PCD Project Manager_2026-06-10_008 - Architectural Elevations.pdf Markup Summary

Subject: Callout
Page Label: AS501 - SITE DETAILS
Author: dsdparsons

HONOR CHARTER SCHOOL BUILDING CORPORATION HONOR CHARTER SCHOOL CONSTRUCTION DOCUMENTS

1 SOUTH ELEVATION
1/8" = 1'-0"

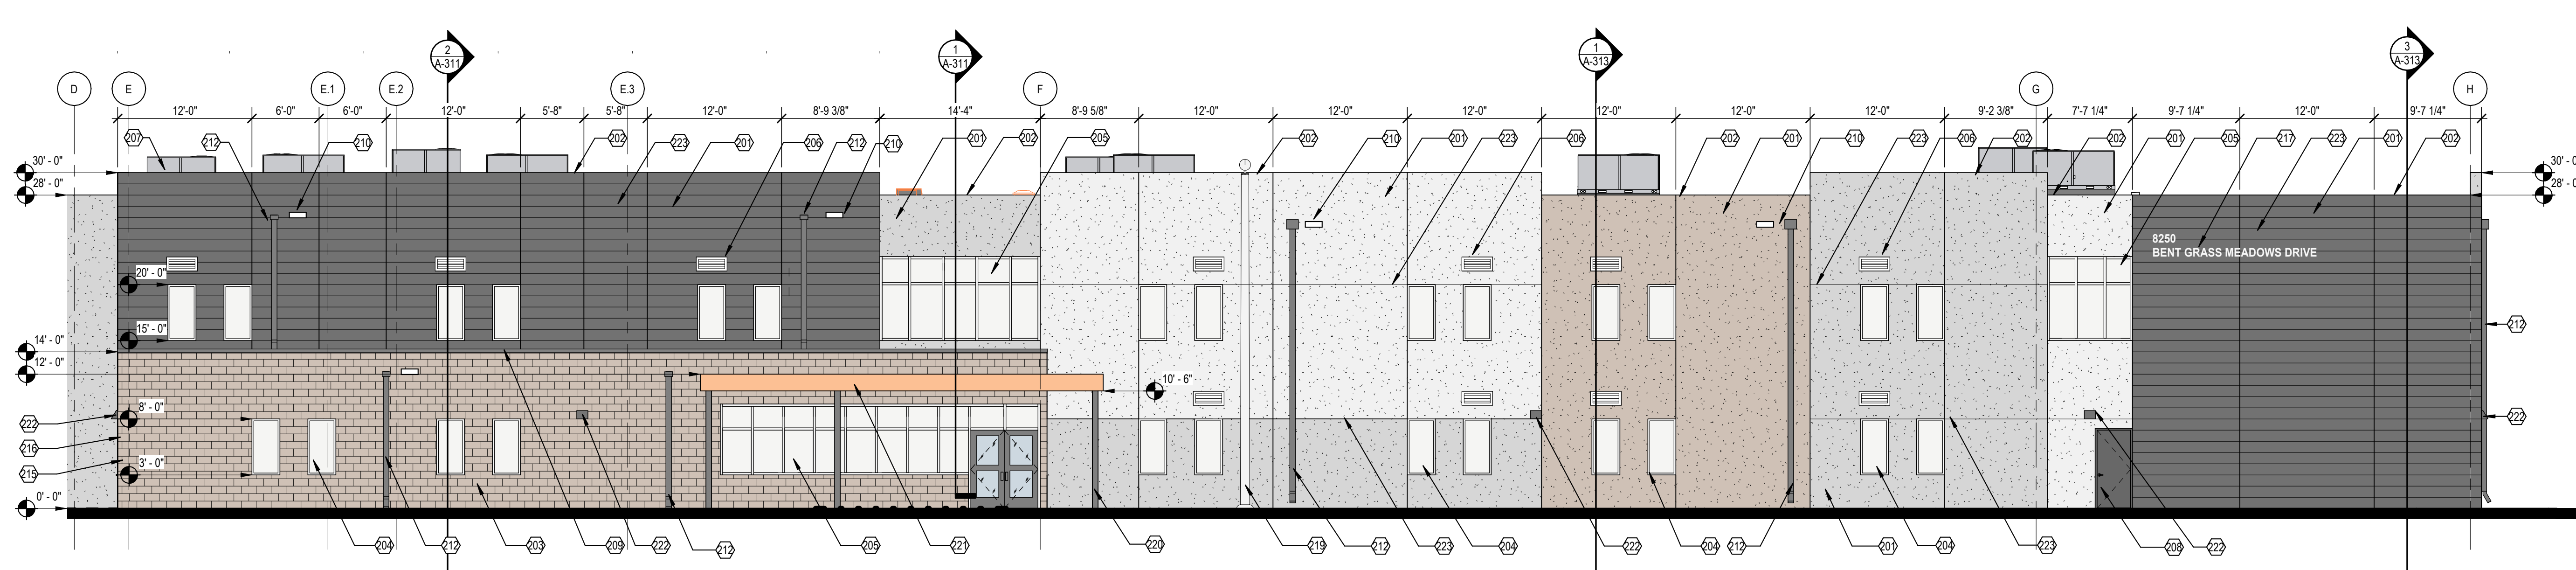
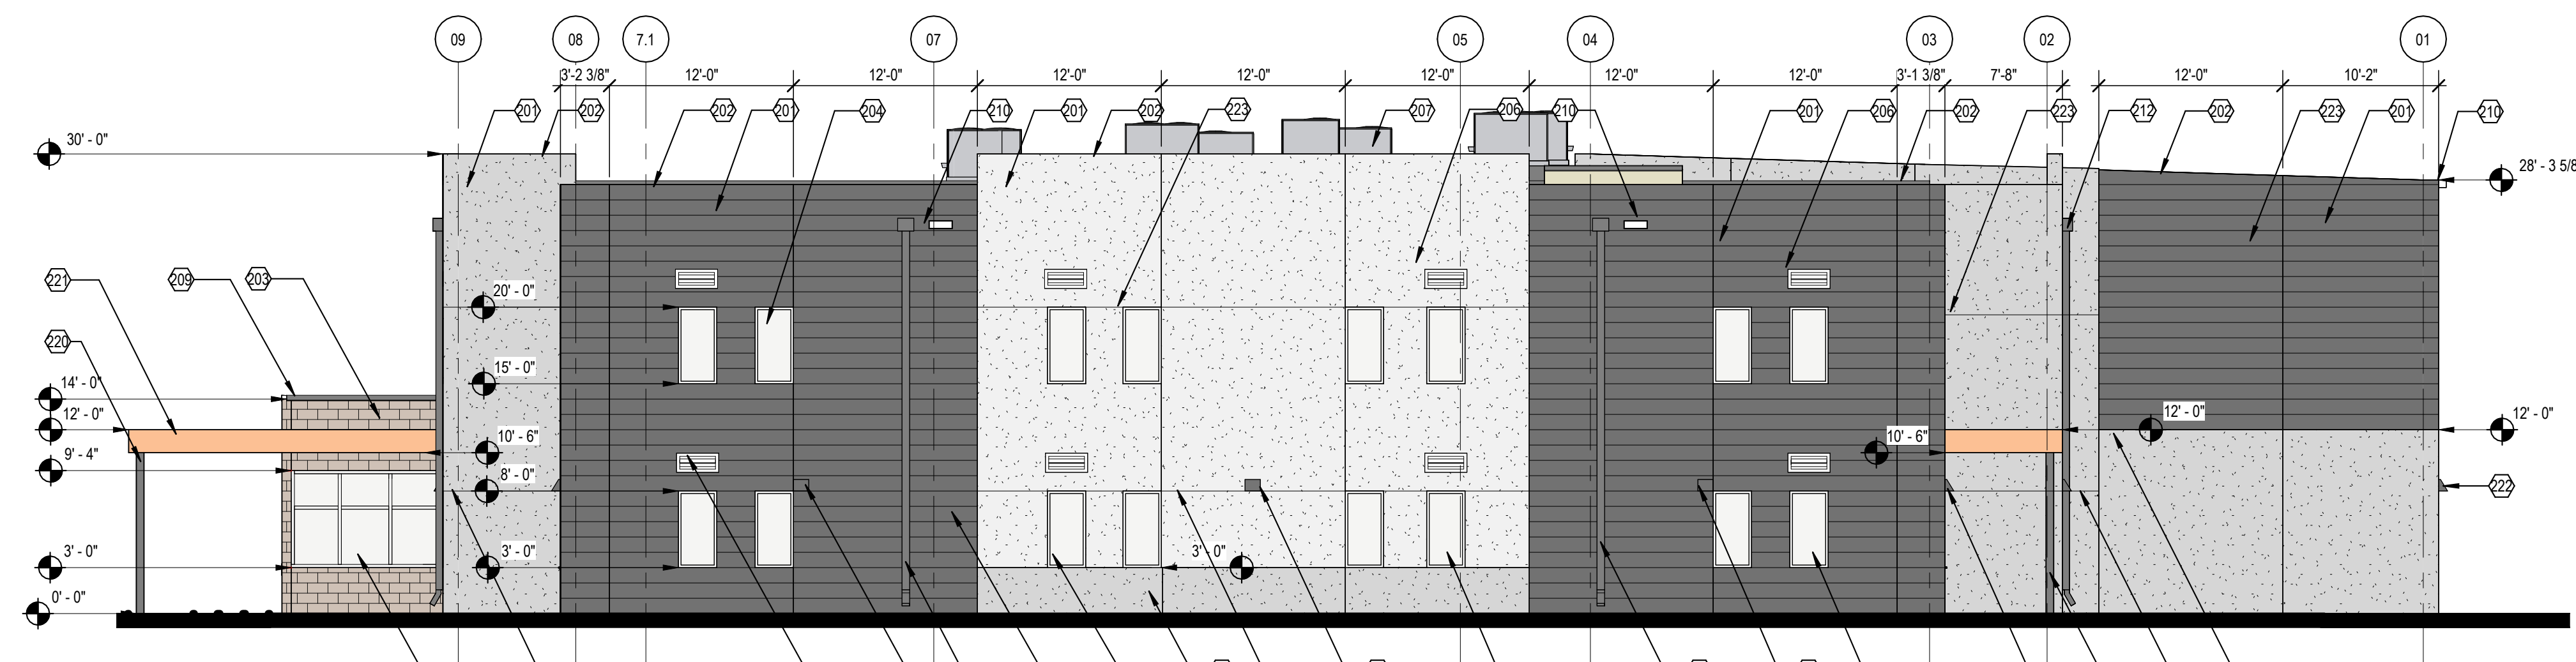
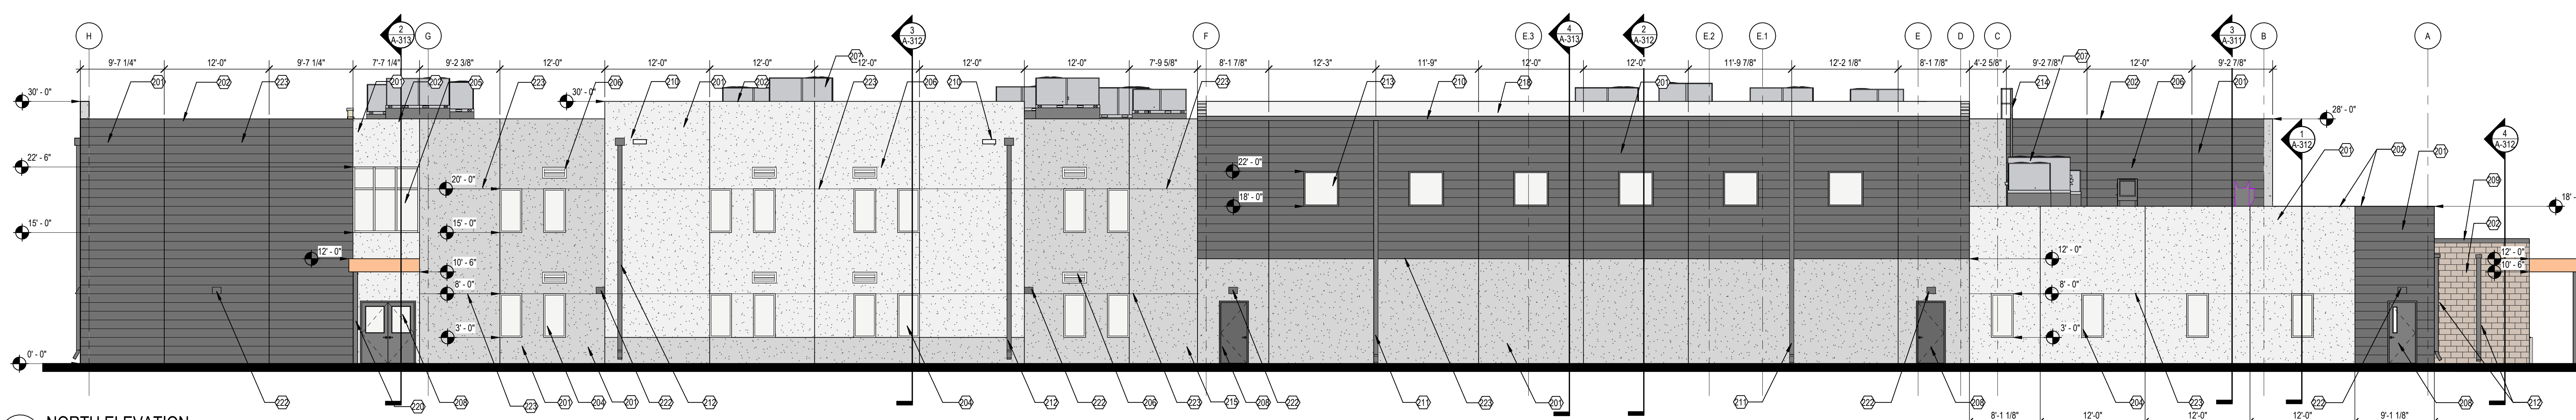
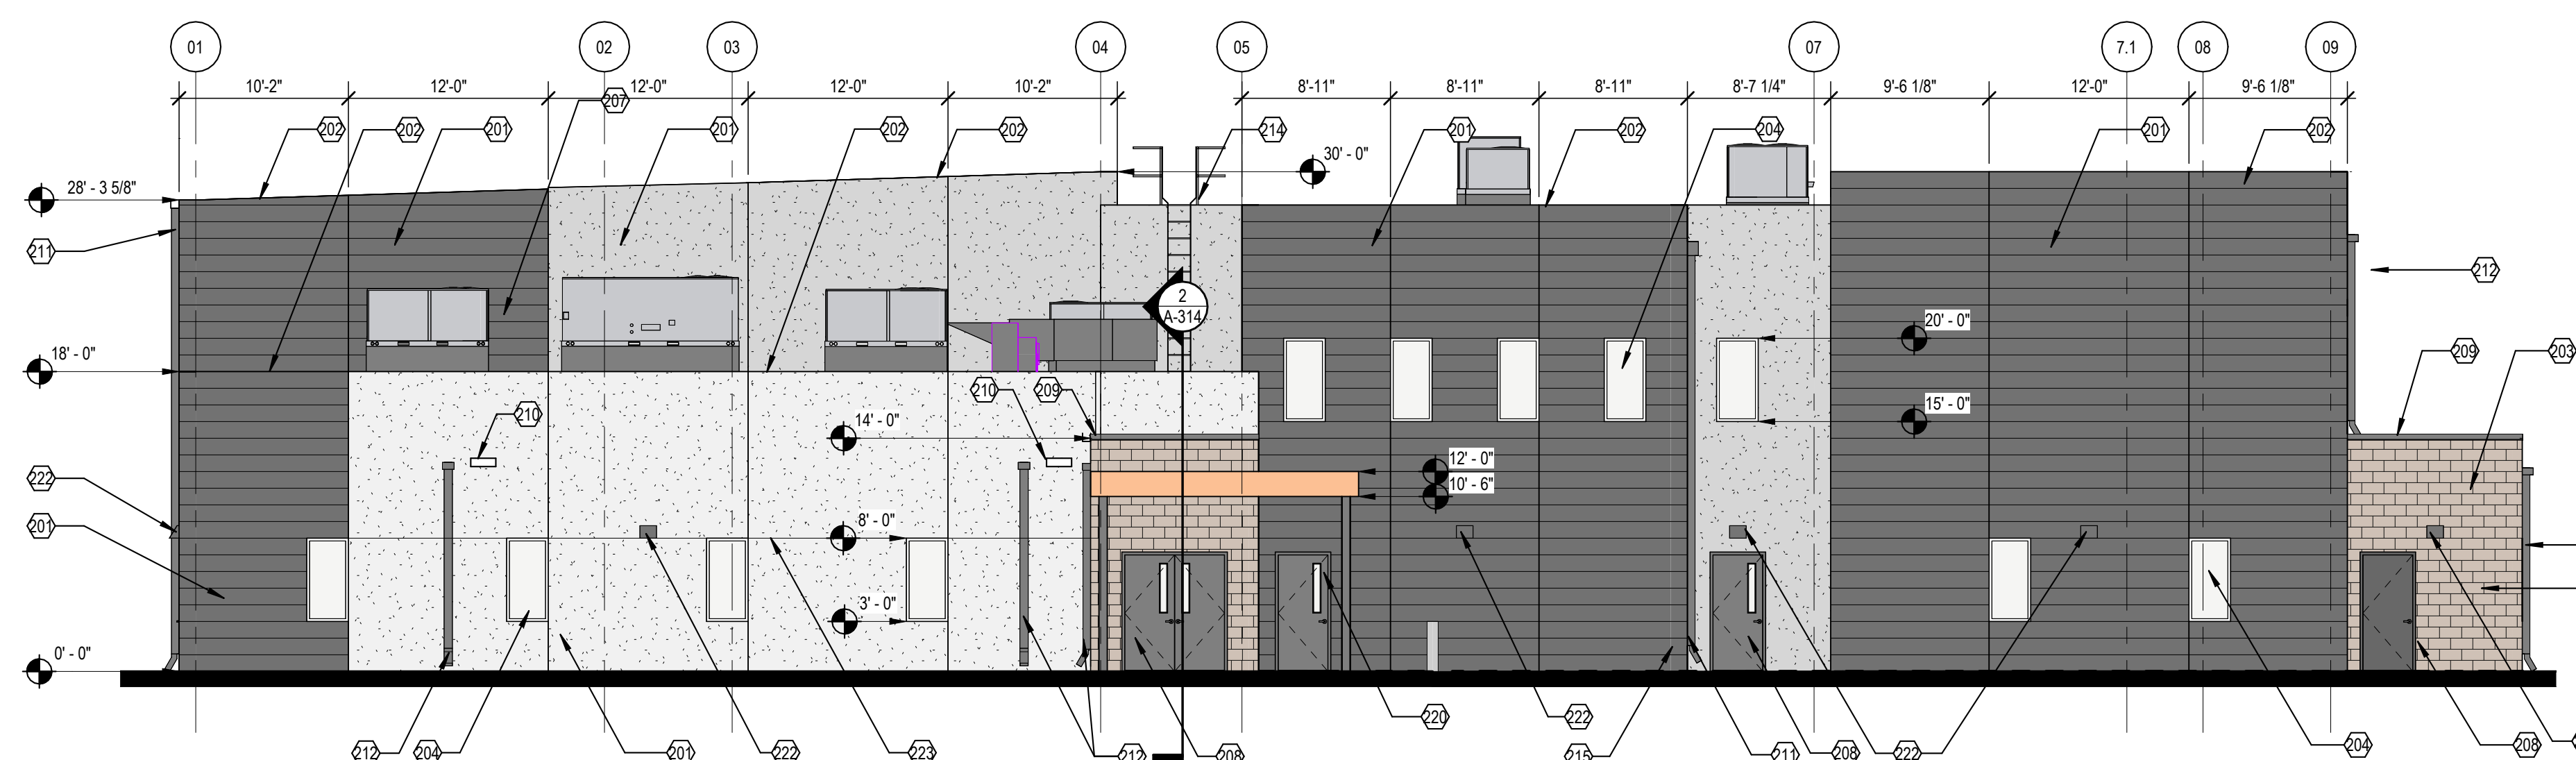
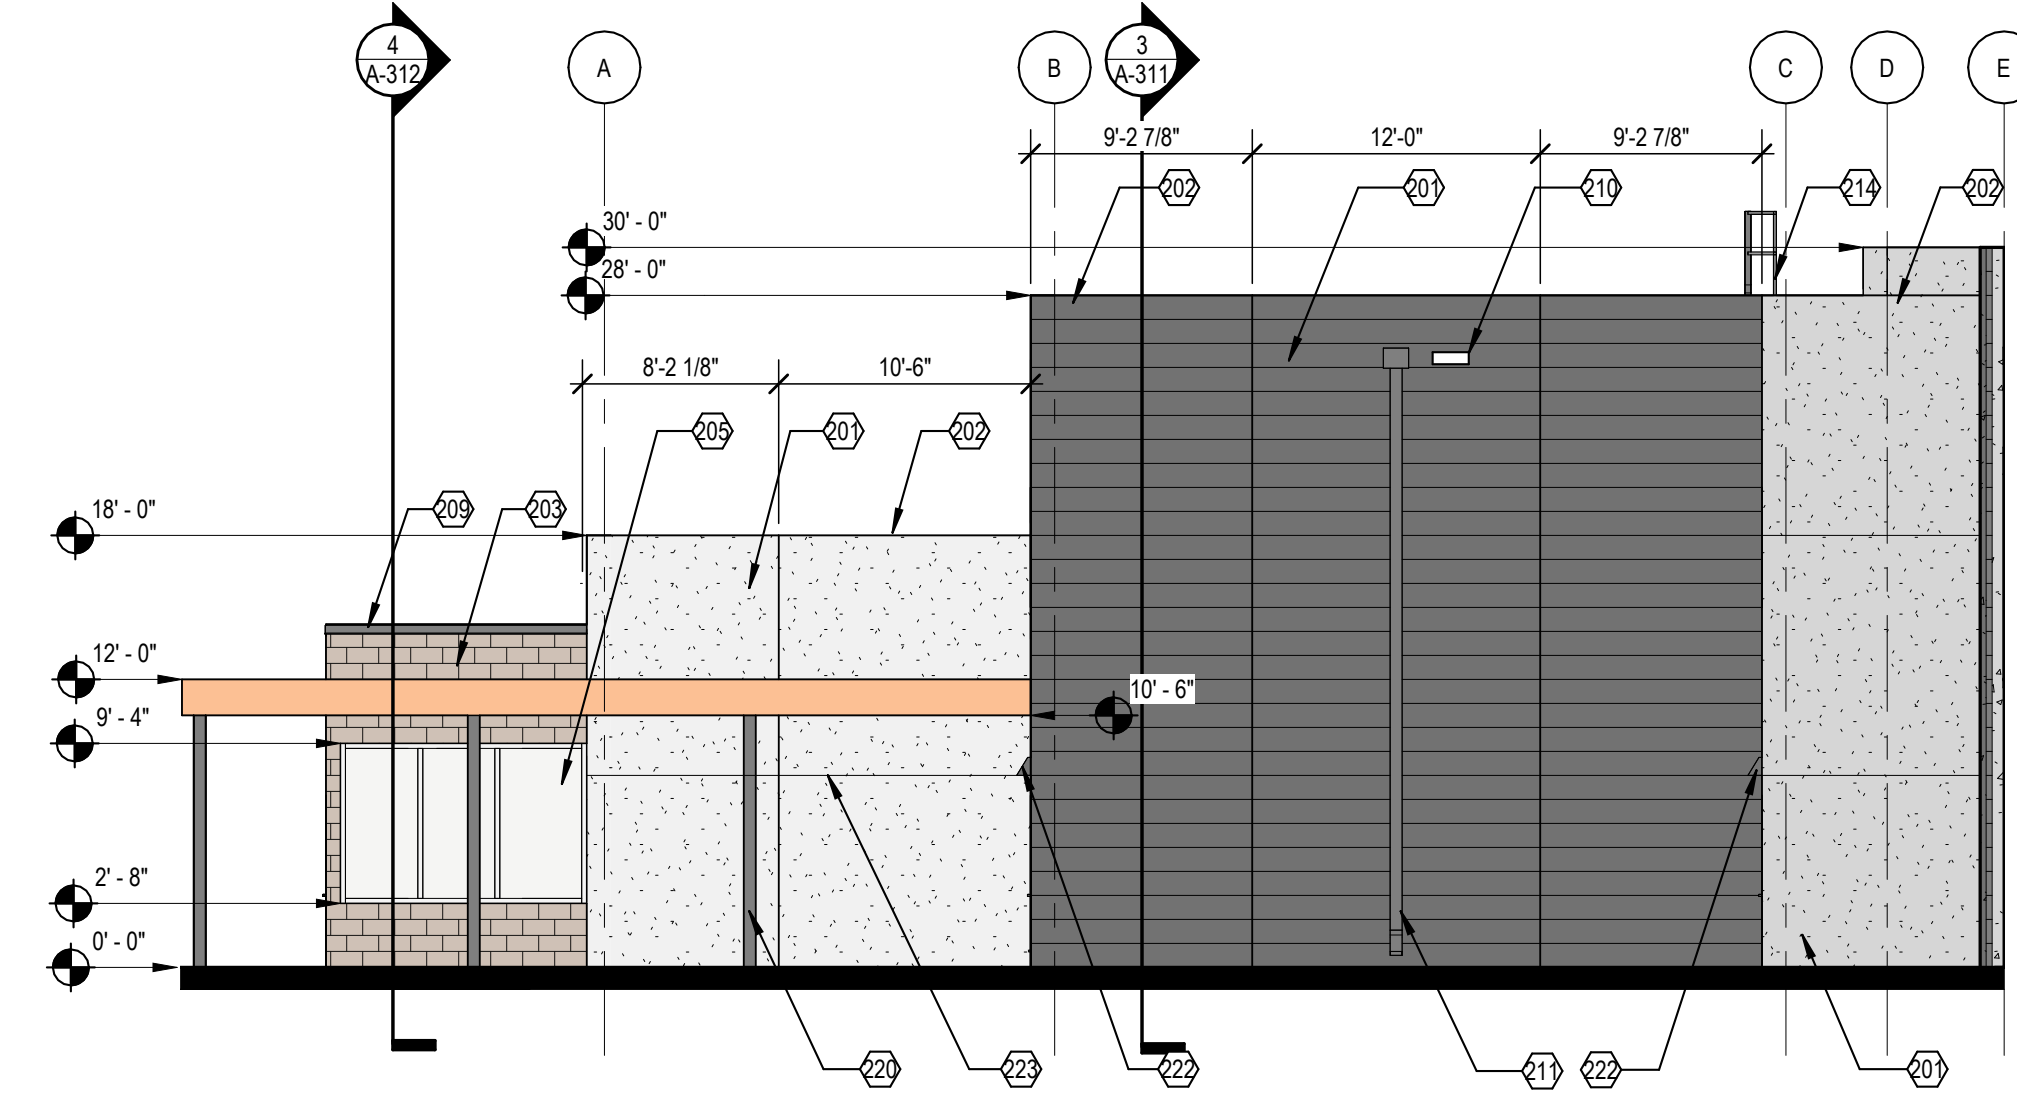
are there any sports fields,
bleachers , screening
walls/fences/ playgrounds

BUILDING ADDRESS AND EXTERIOR SIGNAGE HAS BEEN IDENTIFIED ON THE ATTACHED ELEVATION SHEET A201. ADDRESS NUMBERS WILL BE A MINIMUM OF 8" IN ACCORDANCE WITH 505.1/ 506.1 ADDRESS IDENTIFICATION STANDARDS.
